From: Brian Johnson [mailto:brianjohnson@pwd.org] On Behalf Of AMAP Means Email
Sent: Tuesday, October 13, 2015 10:23 AM
To: Patrick Ducas <patrickd@ducasconstruction.com>
Subject: 415 Cumberland Avenue - Portland - New Service Information

From: David Margolis-Pineo
To: Patrick Ducas
CC: Barbara Barhydt; Benjamin Pearson; Helen Donaldson; Jean Fraser; Jef...
Date: 10/20/2015 10:20 AM
Subject: Wastewater Capacity Application Approval for 415 Cumberland Ave
Attachments: David Margolis-Pineo.vcf

RE: The Capacity to Handle Wastewater Flows from 415 Cumberland Ave

5 Top Roof drainage plan
1/4" = 1'-0"

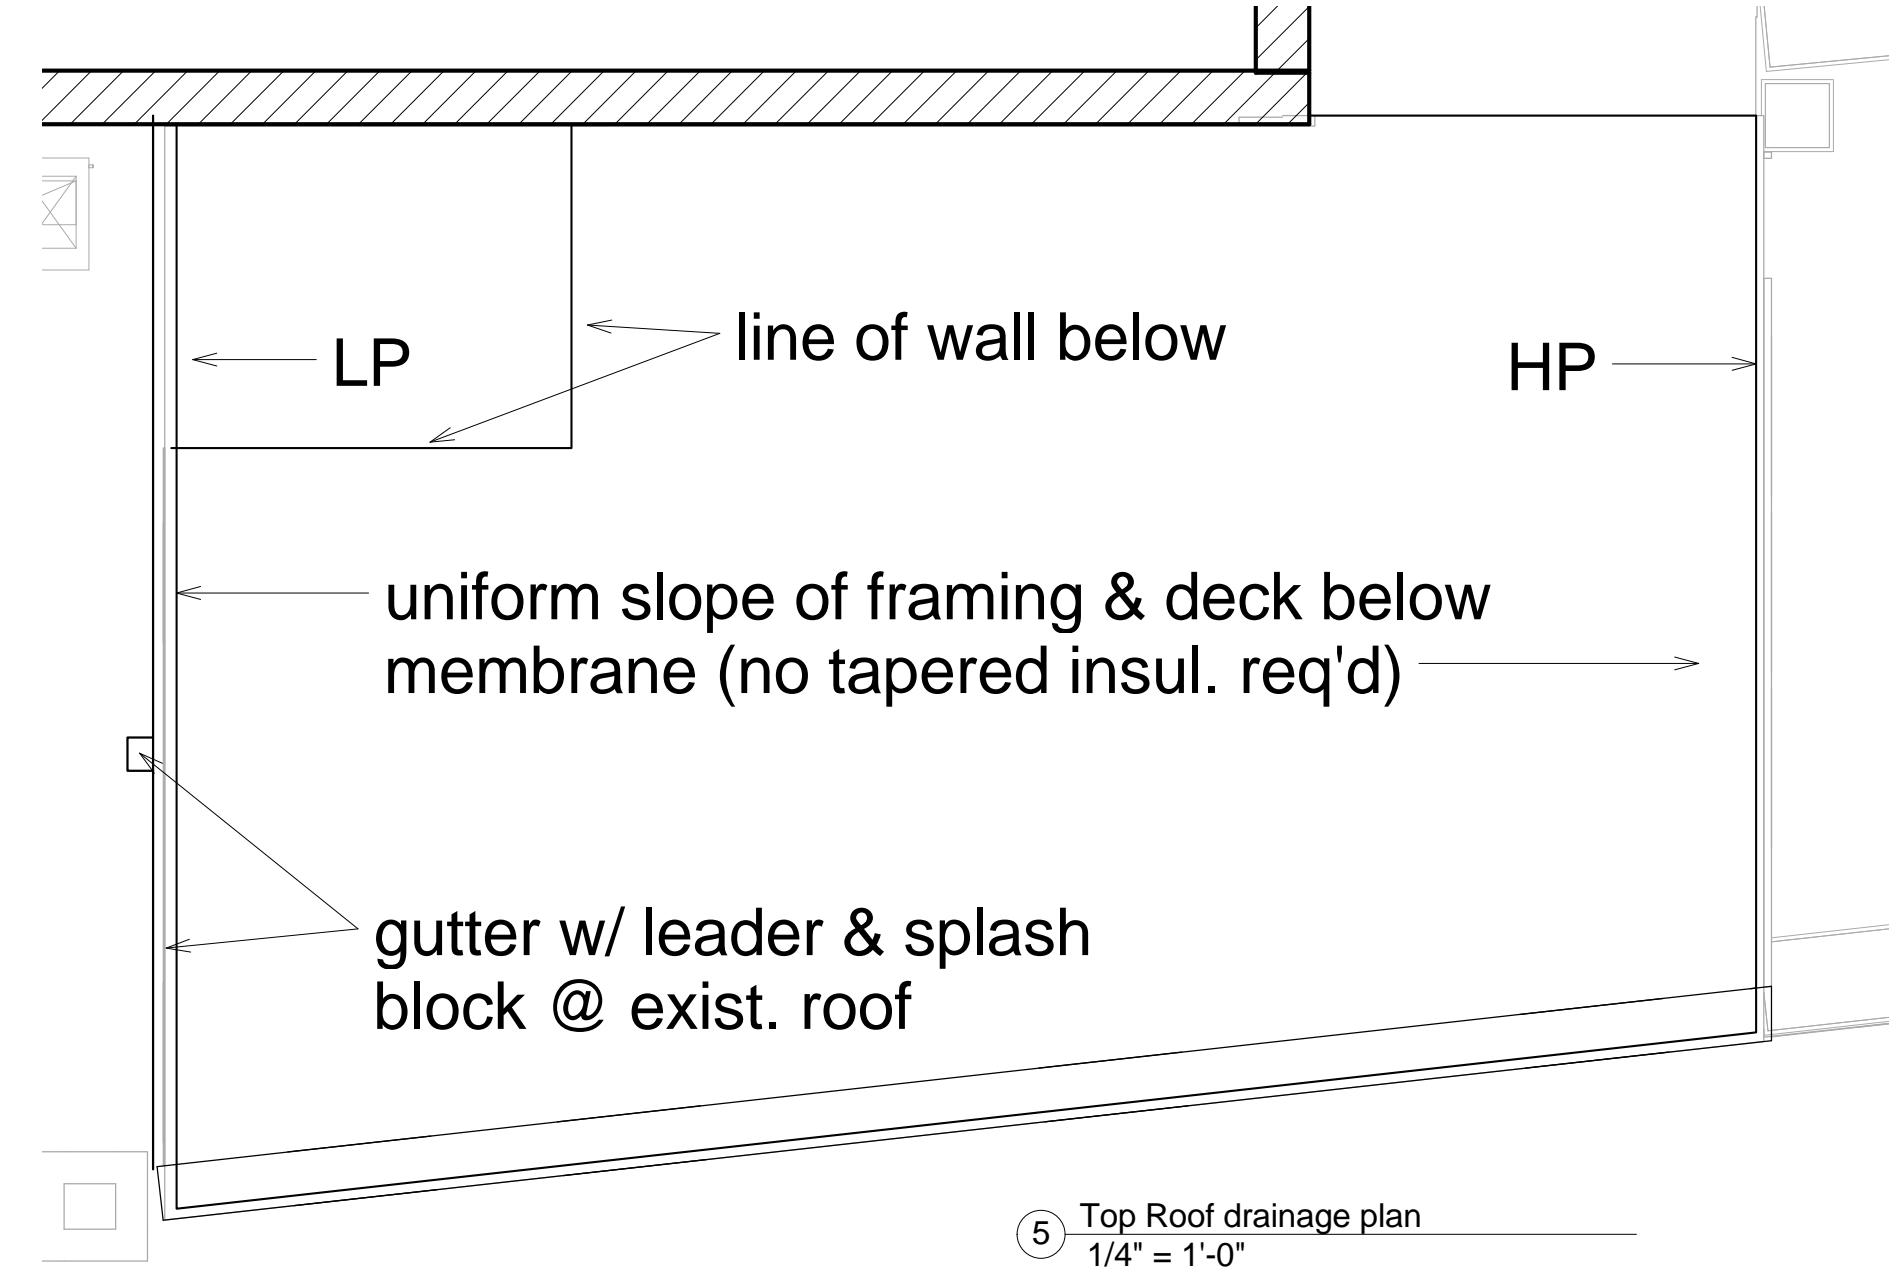
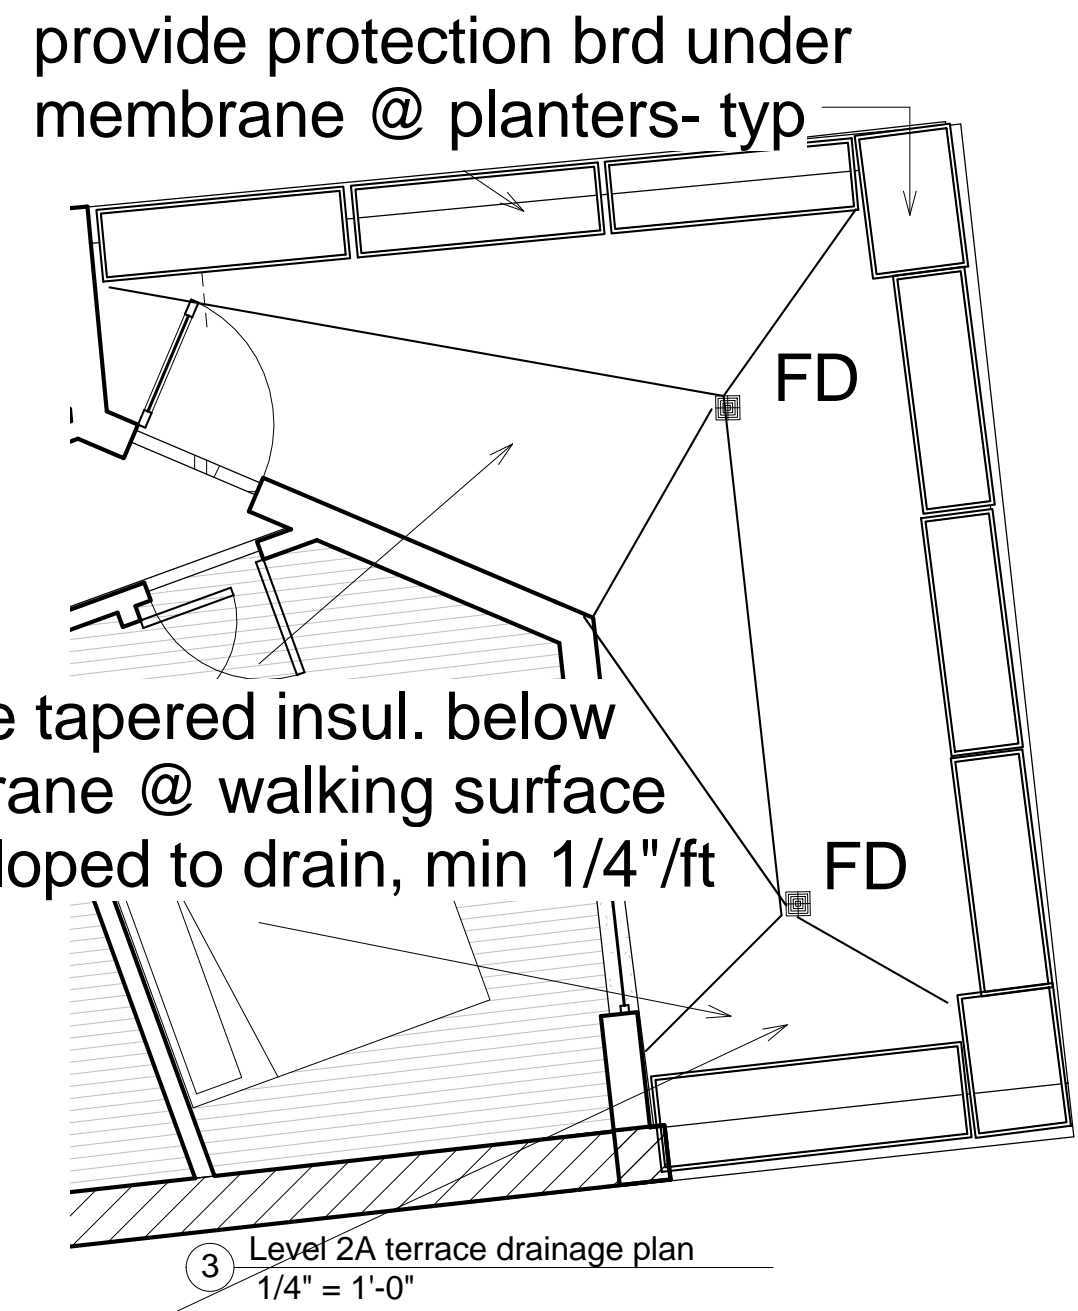
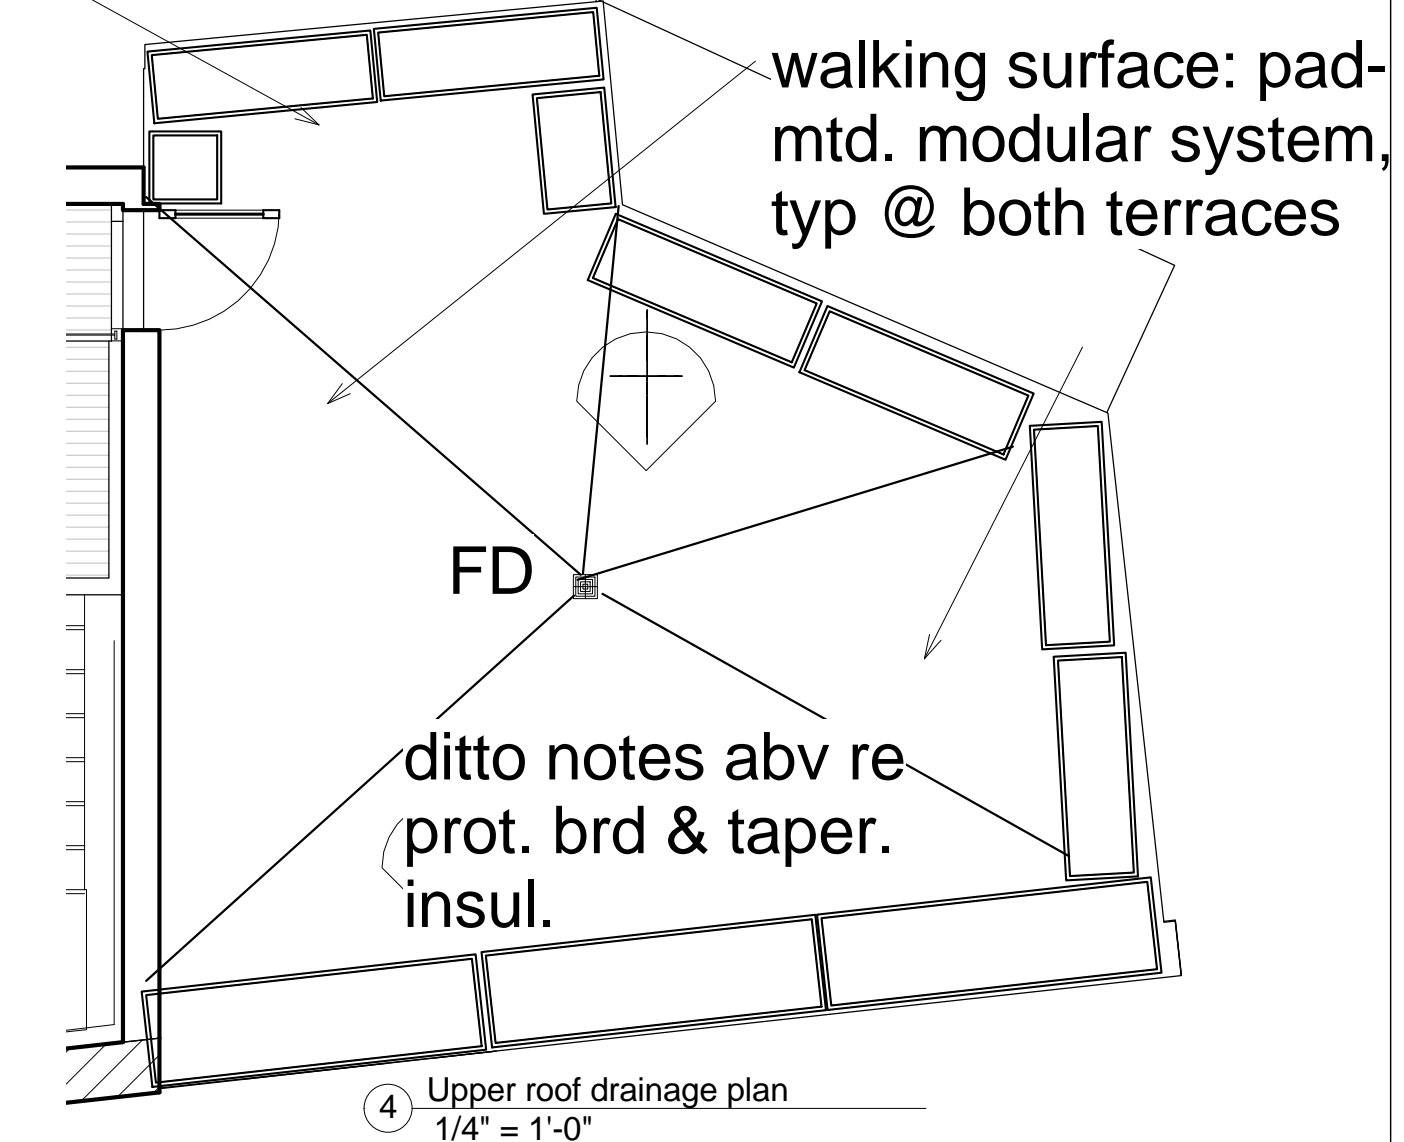
The Department of Public Services, which includes the Water Resource Division, has reviewed and determined that the downstream sewers from 415 Cumberland Ave has the capacity to convey the estimated 1,440 gallons per day of wastewater which will be generated from this multi family housing project. It is understood that no sources of stormwater runoff, roof drainage, or any other non-contaminated water shall be introduced to the wastewater collection system from this development. If roof drainage is currently discharging to the sanitary sewer system, we are requesting that the roof discharge be redirected to sidewalk or street level.
